From: Daun Johnson on behalf of Planning.Responses
Sent: 04 April 2019 10:35
To: Planning Scanning
Subject: FW: Planning Consultation on: BE/38/19/PL

Engineers Comments Regarding Flood Risk and Surface Water Drainage
Flood Risk

APPLICATION **BE/38/19/PL**

Description of Works: Creation of temporary soil storage bund associated with
development of adjoining site at Saltbox

TOP SOIL RELOCATION
LOCATION PLAN
1744-TS-P01-A

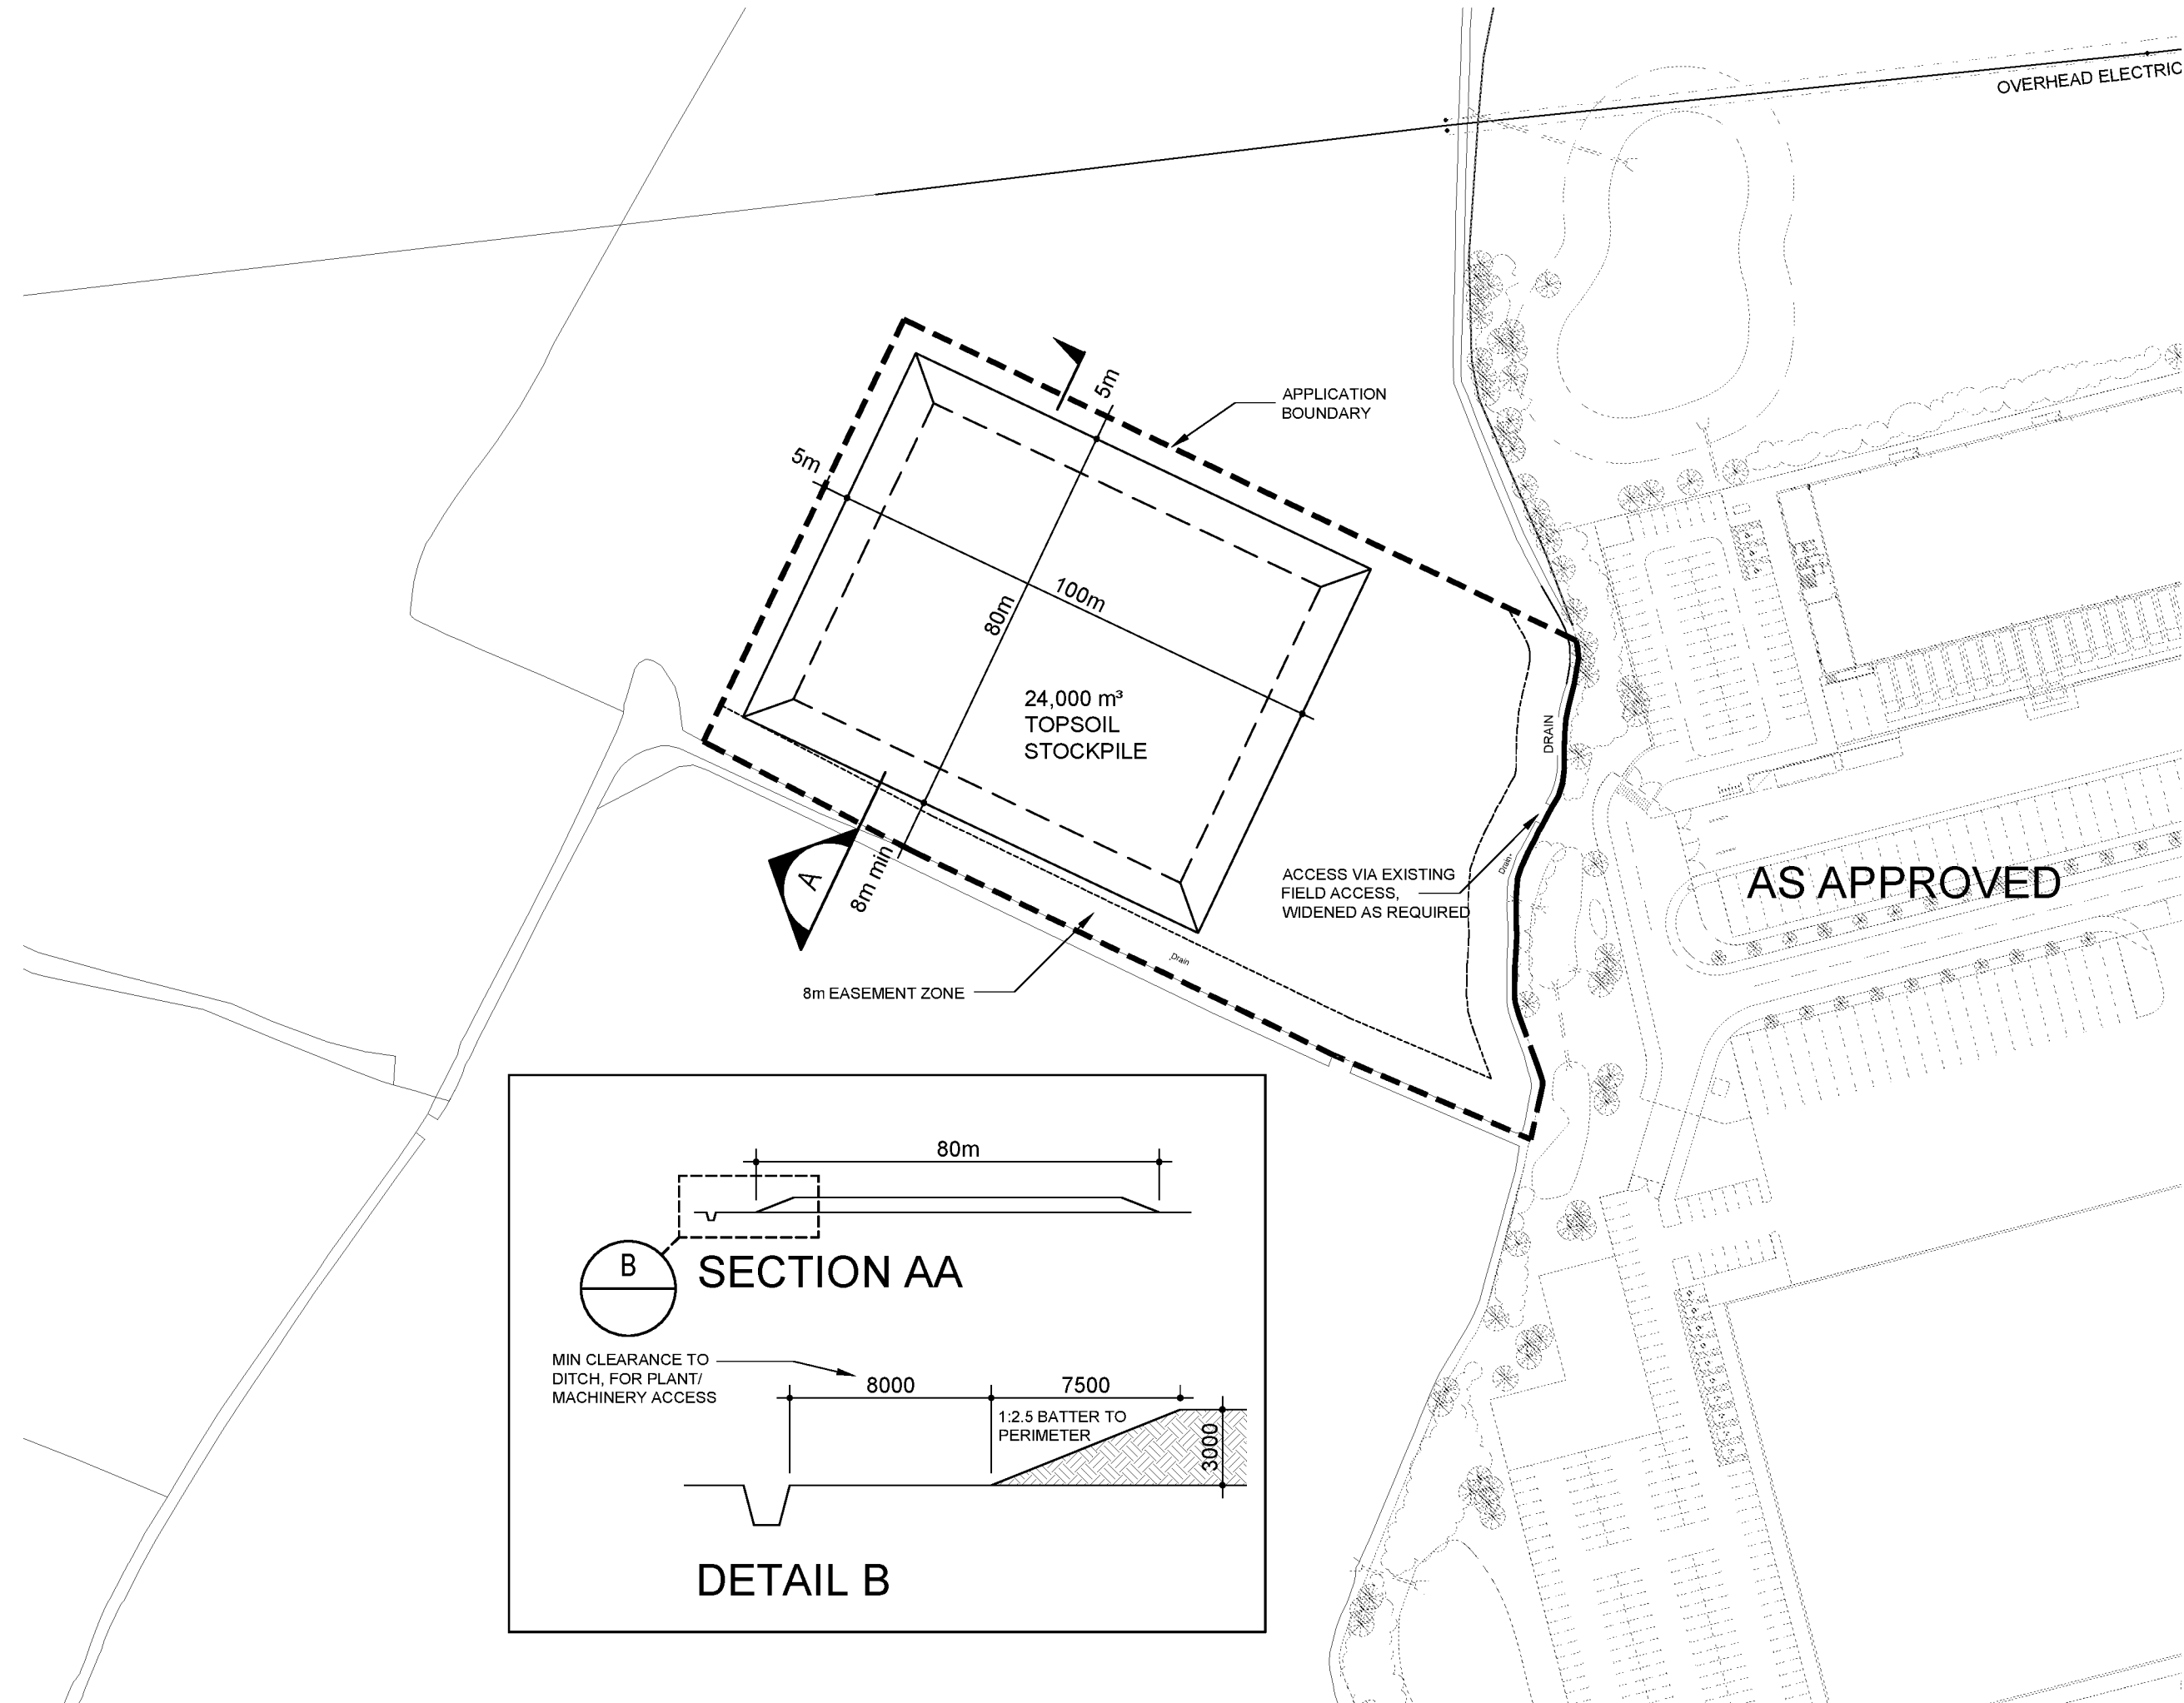
The application site is within flood zone 3. We know of historic flooding events on the site and the adjoining saltbox site in both 1994 and 2012. Further flooding has undoubtedly occurred.

A flood risk assessment should be submitted, and the Environment Agency should be consulted. The 24,000m³ stockpile could displace flood water and increase flood risk elsewhere. This should be discussed with the Environment Agency, and mitigation measures formed if and as required.

If any covering of the stockpile is proposed we would require some formal drainage features to be installed to ensure that flood risk is not increased elsewhere. Please can the applicant confirm that the stockpile will not be covered, if this is confirmed we will not require any drainage conditions to be imposed.
